STATE OF NORTH CAROLINA  
DEPARTMENT OF TRANSPORTATION

SUBJECT: Richmond County, Ellerbe Bypass and Ellerbe Connector (NC  
Extension) US 220; TIP Number R-2231B;  
Federal Aid Project Number NHF-45-1(49);  
State Work Order Number 8.T550803

Richmond County  
Ellerbe Bypass and Ellerbe Connector (NC Extension), US 220  
Federal Project No. NHF-45-1(49)  
State Project No. 8.T550803  
TIP No. R-2231B

Subject: Action ID No. 199400590, TIP No. R-2231, Ellerbe Bypass, Richmond Counties, North Carolina.

SHEET 28 OF 43

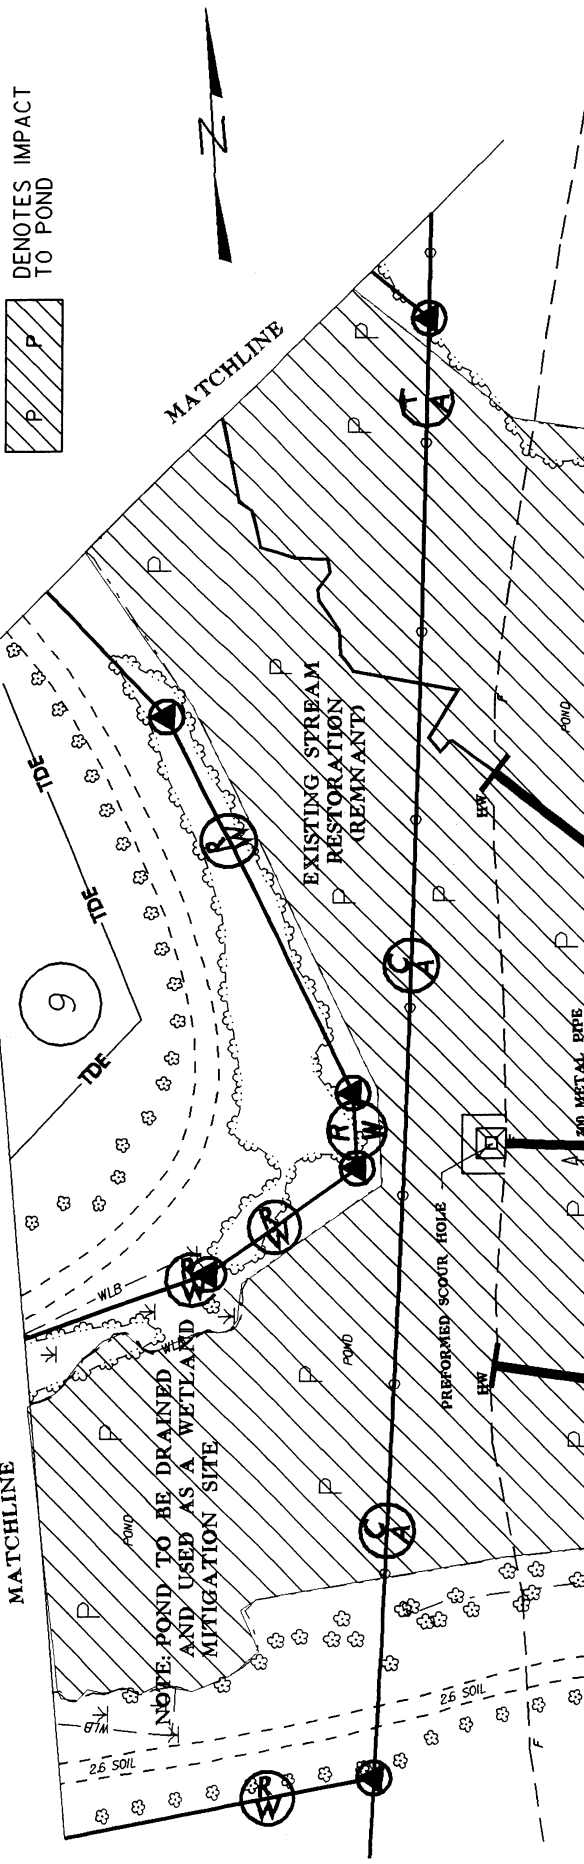
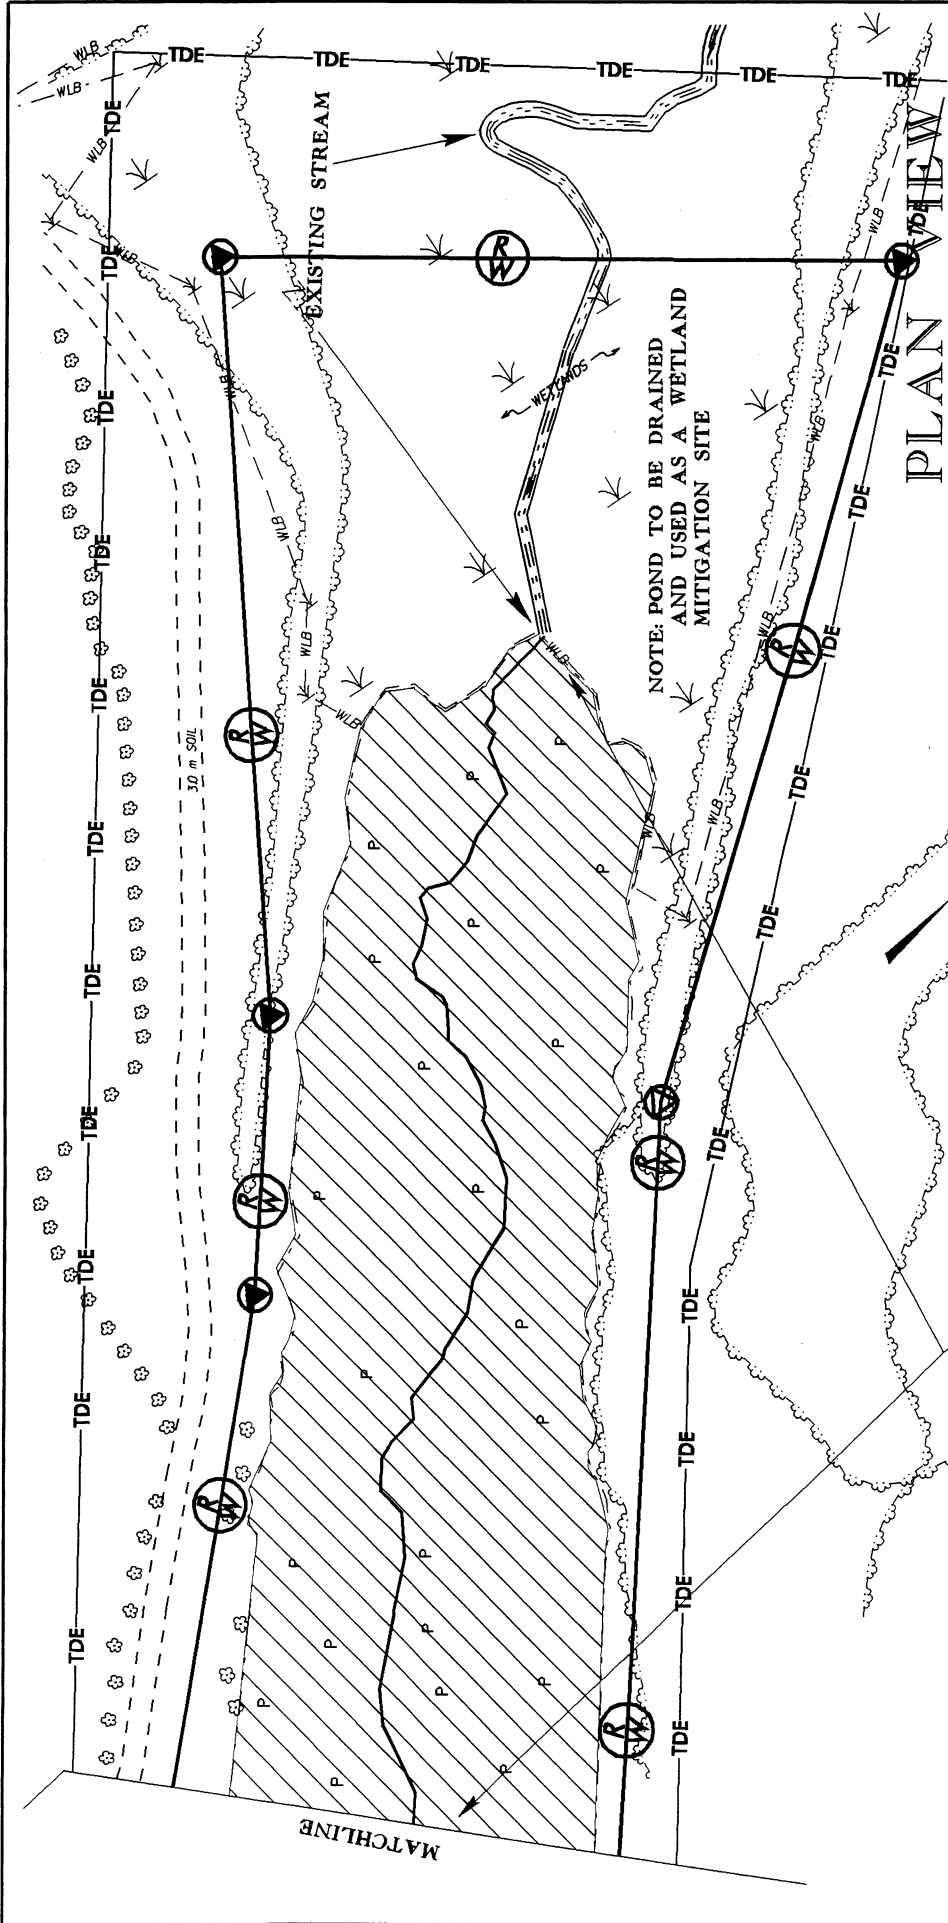
**R-2231B, permit drawing sheet 28 of 43, Station 27+00 - 28+75, Site 6**

The referenced modified Section 404 permit authorized the modification to the east side of the Myrick Pond mitigation site. However, NCDENR, as a condition of their revised Section 401 Certification has requested that the redesign incorporate an additional structure within the impoundment area. The structure requested by NCDENR would be a rip-rap berm with cross vane rock wiers located at the ends of the road culverts and extending to the stepped outfall structure previously authorized by the August 26, 2004 modification.

I have determined that the proposed project modification described above is not contrary to the public interest and therefore, the DA permit is hereby modified to include authorization for the modification listed above and as shown on the revised permit drawings (enclosed).
